Recommendation Report for Planning Permission**REF NO:** AB/115/17/PL**LOCATION:** Former Arundel Equine Hospital
Tortington Lane
Arundel**PROPOSAL:** Erection of 1 No. dwelling (resubmission following AB/81/16/PL). This application is a Departure from the Development Plan**SITE AND SURROUNDINGS**

drawing title:
PLOT 5 – Plans

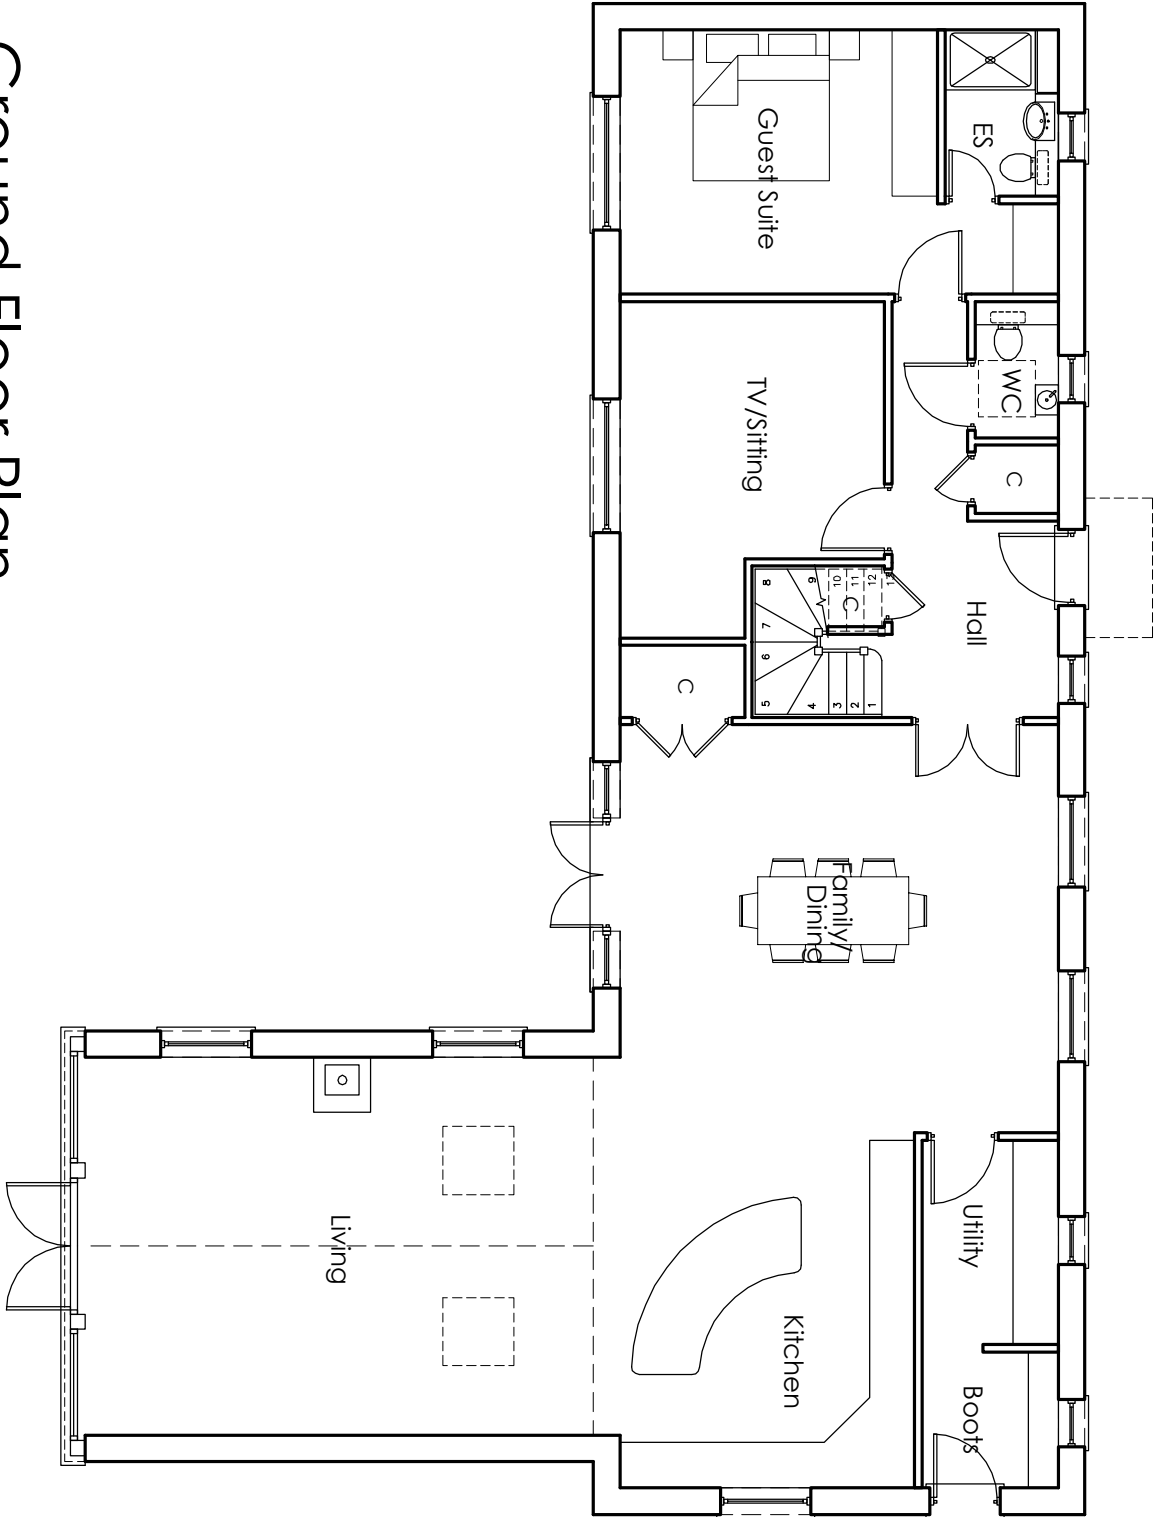
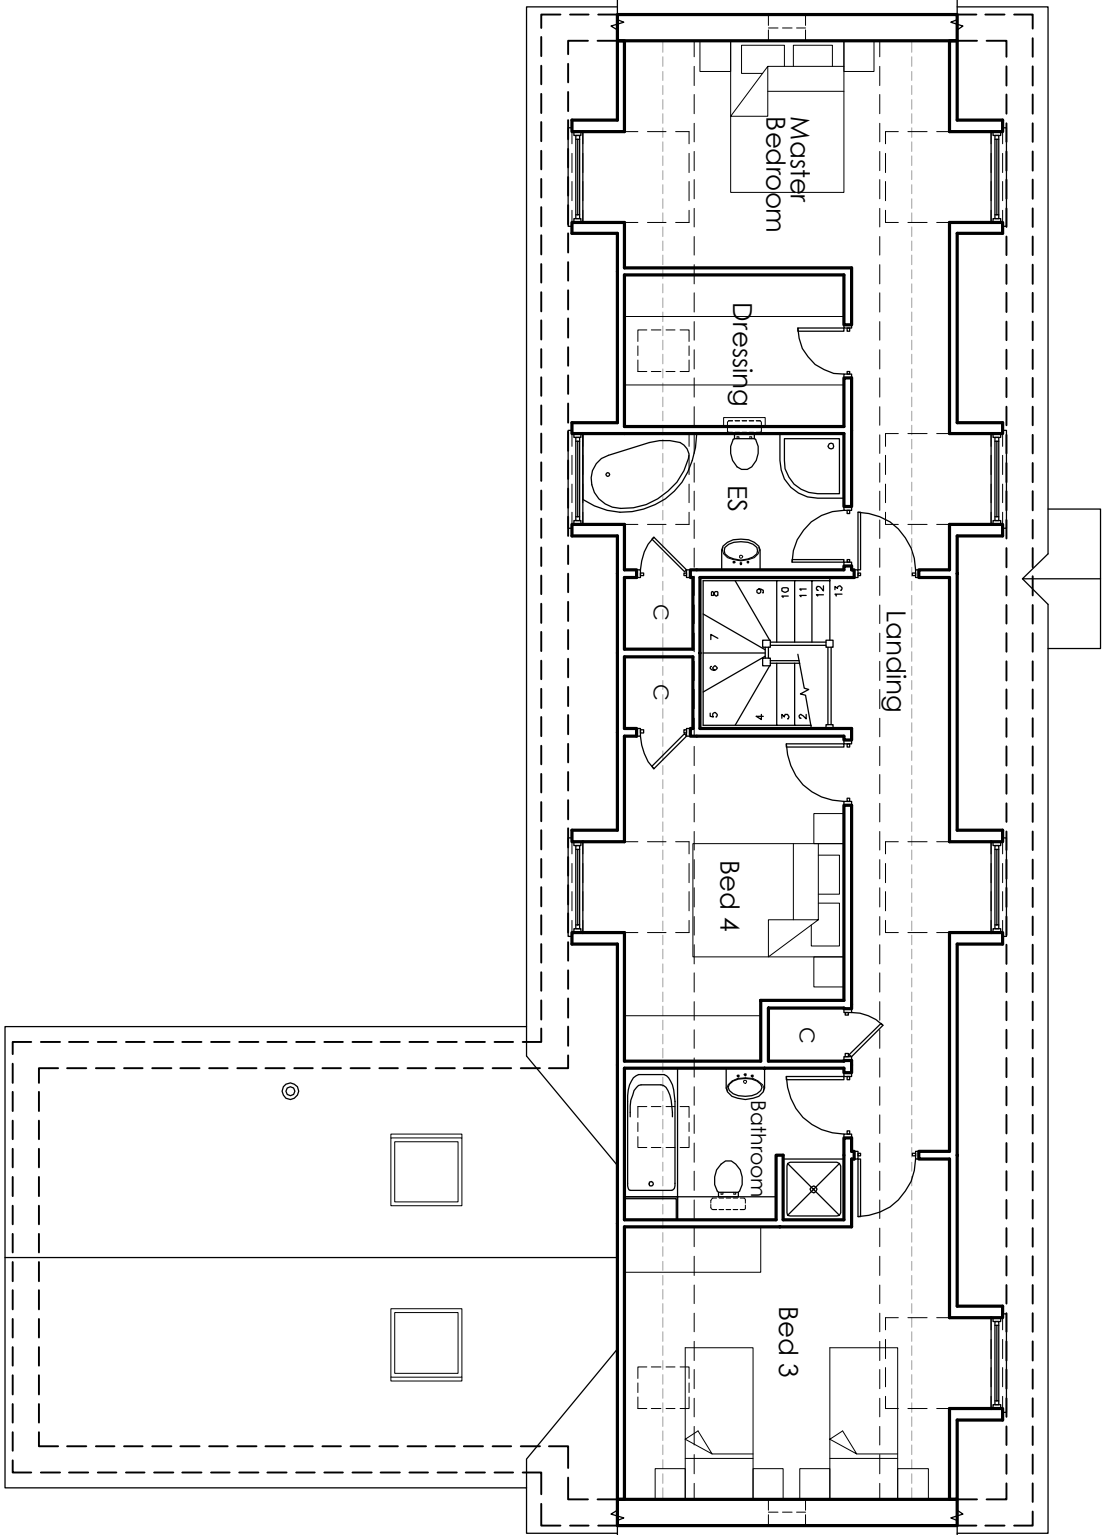
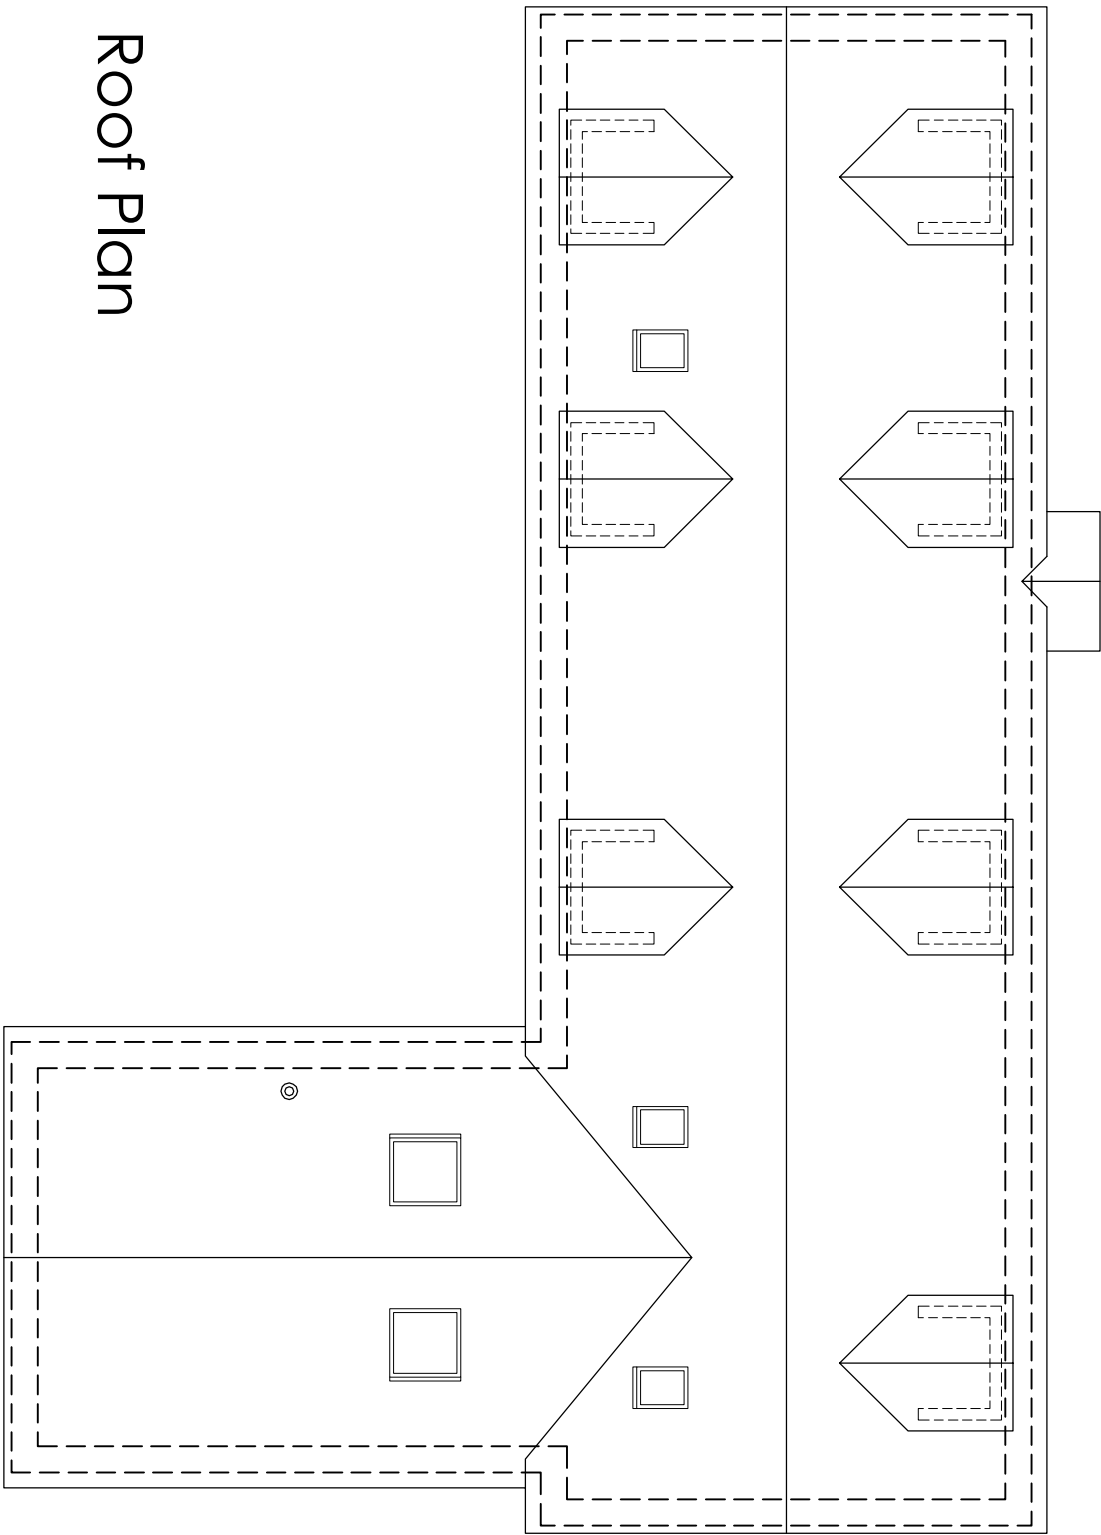
The Local Planning Authority is applying internal and external space standards. The proposal would meet the National Internal space standards for a two storey 4 bedroom dwelling for 6 people. 124 sq metres are required and 234 sq metres are provided. The bedroom and living areas also meet the policy requirements. The external space standards set out in policy DDM3 of the Emerging Local Plan require 100sq m and the application provides approximately 500sqm. The minimum garden depth of 10m is also met.

The dwelling would have one first floor window in the side elevation which could result in adverse overlooking of the adjacent recently approved dwelling, but this could be controlled by an obscure glazing.

job number: **1781** drawing number: **P501** revision: **C**

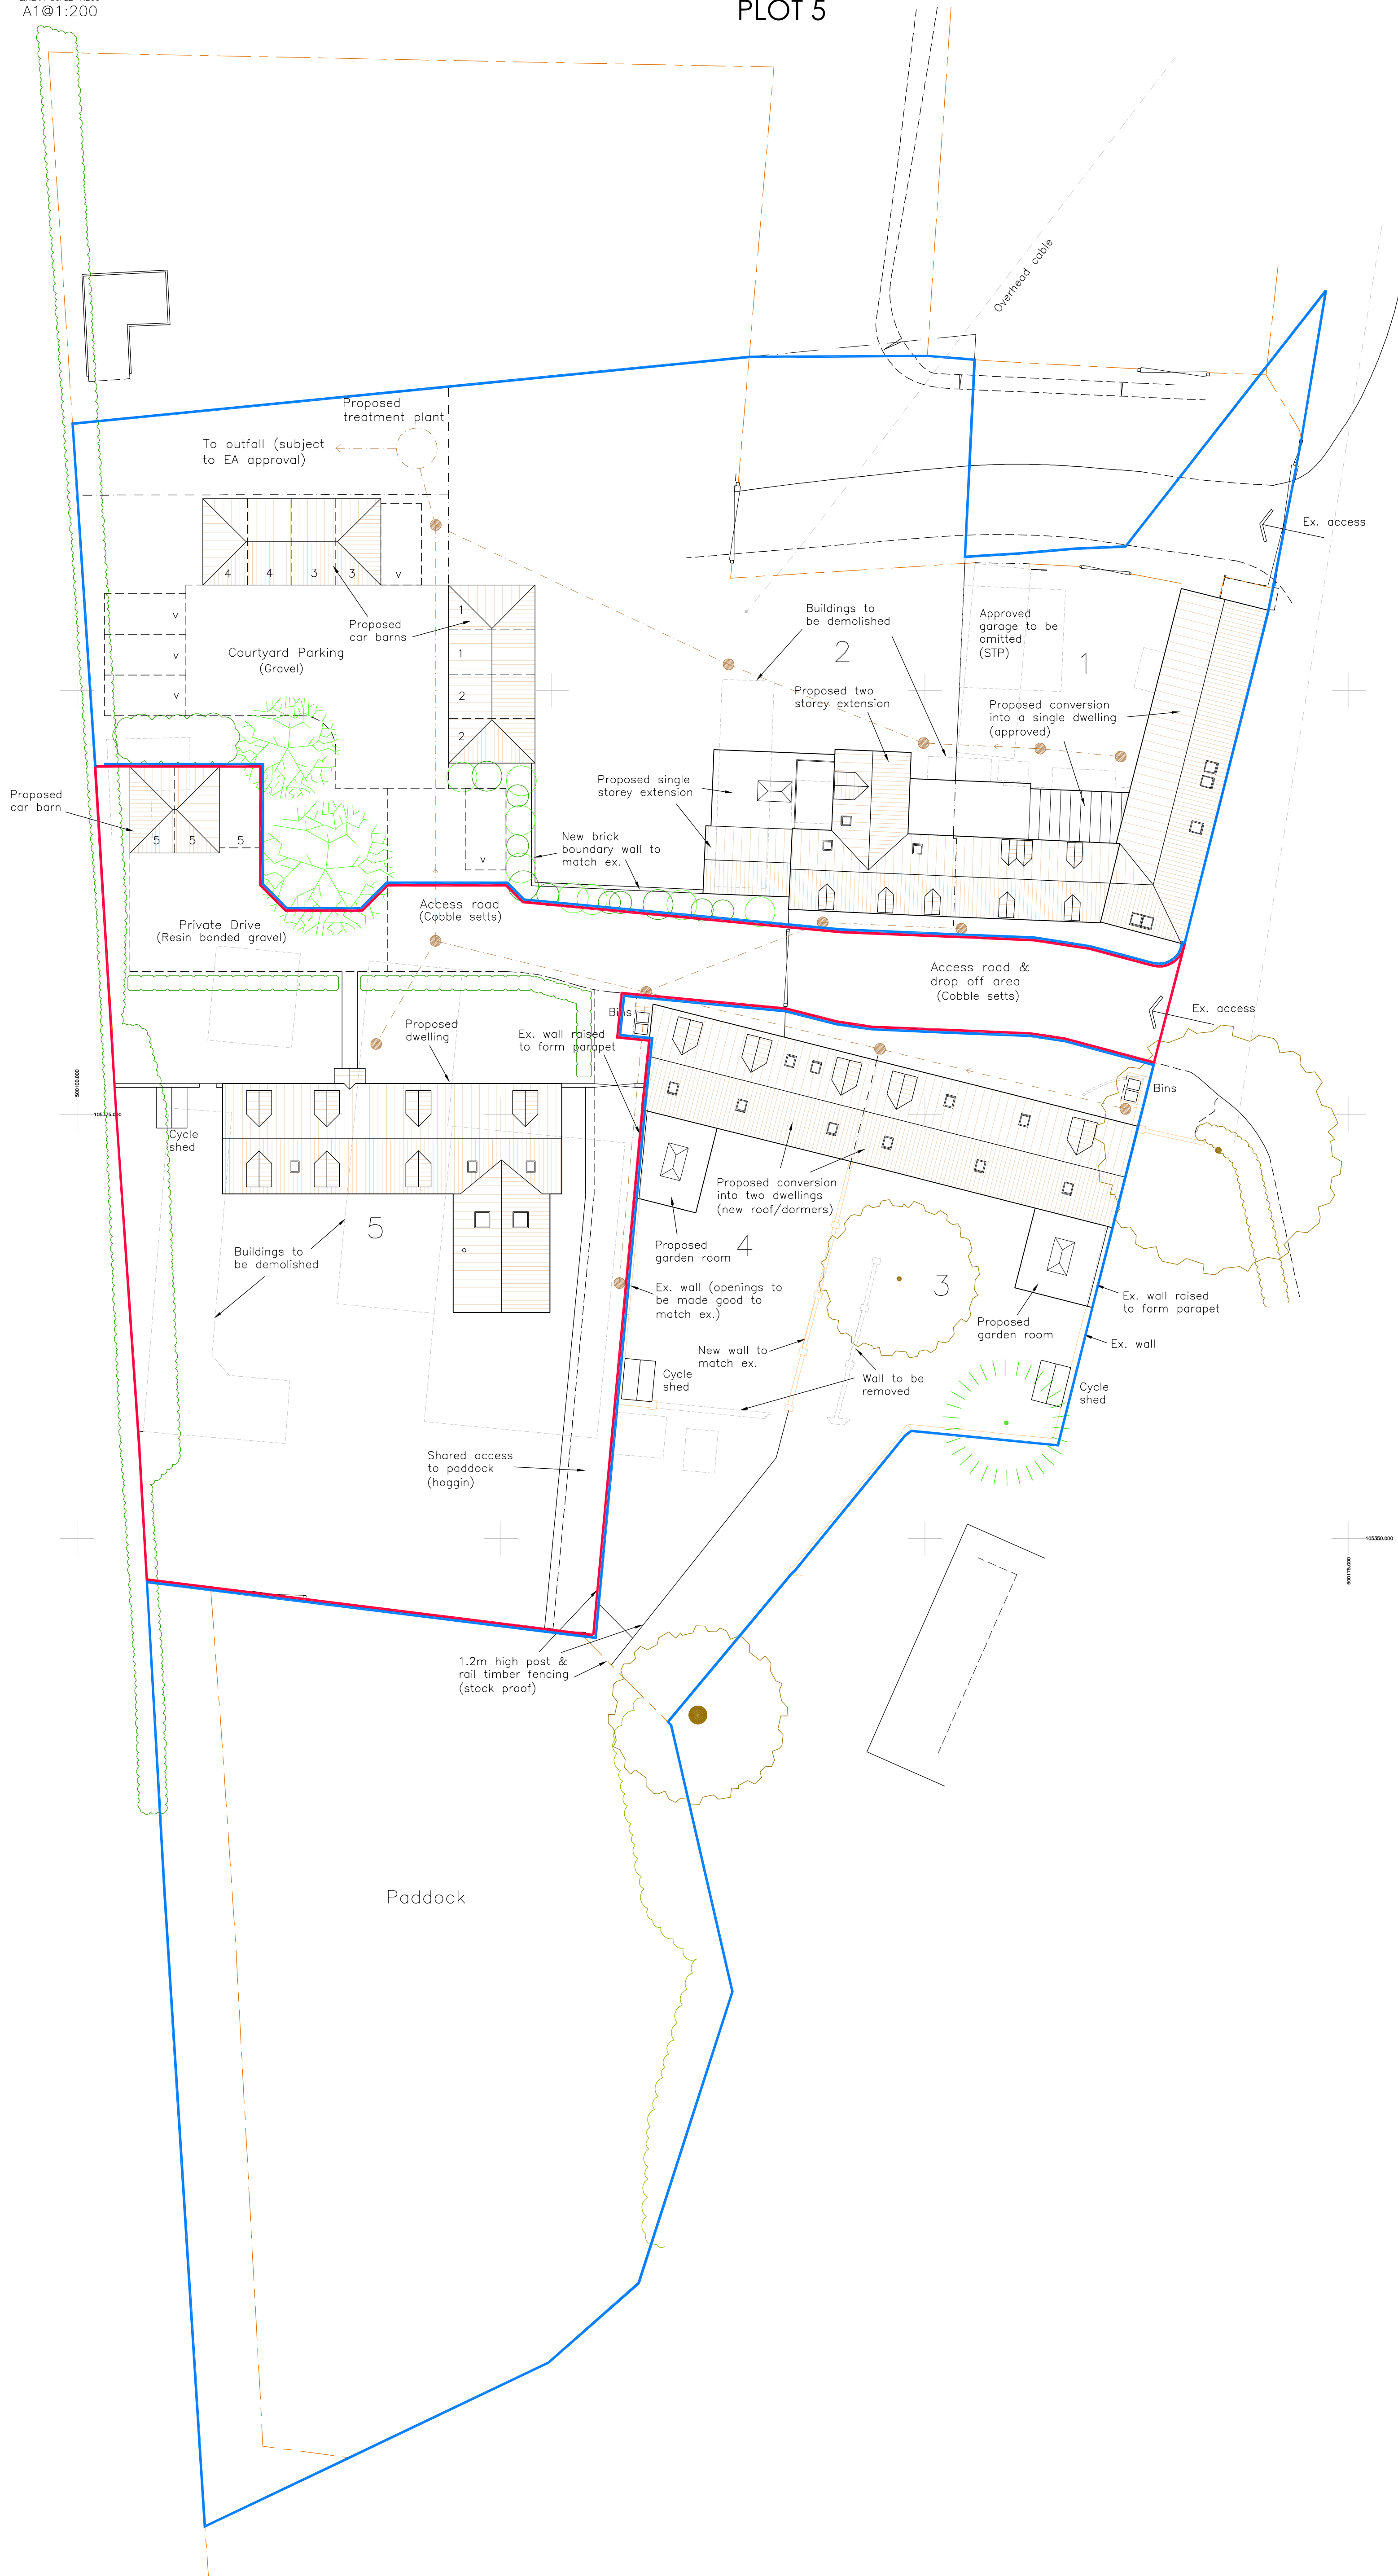
The proposal has also increased the curtilage of the application site to include additional land to the frontage for car parking. This could easily be accommodated within the previously approved residential curtilage and represents an unnecessary expansion of built form in the countryside which is contrary to policy GEN3 of Arun District Local Plan.
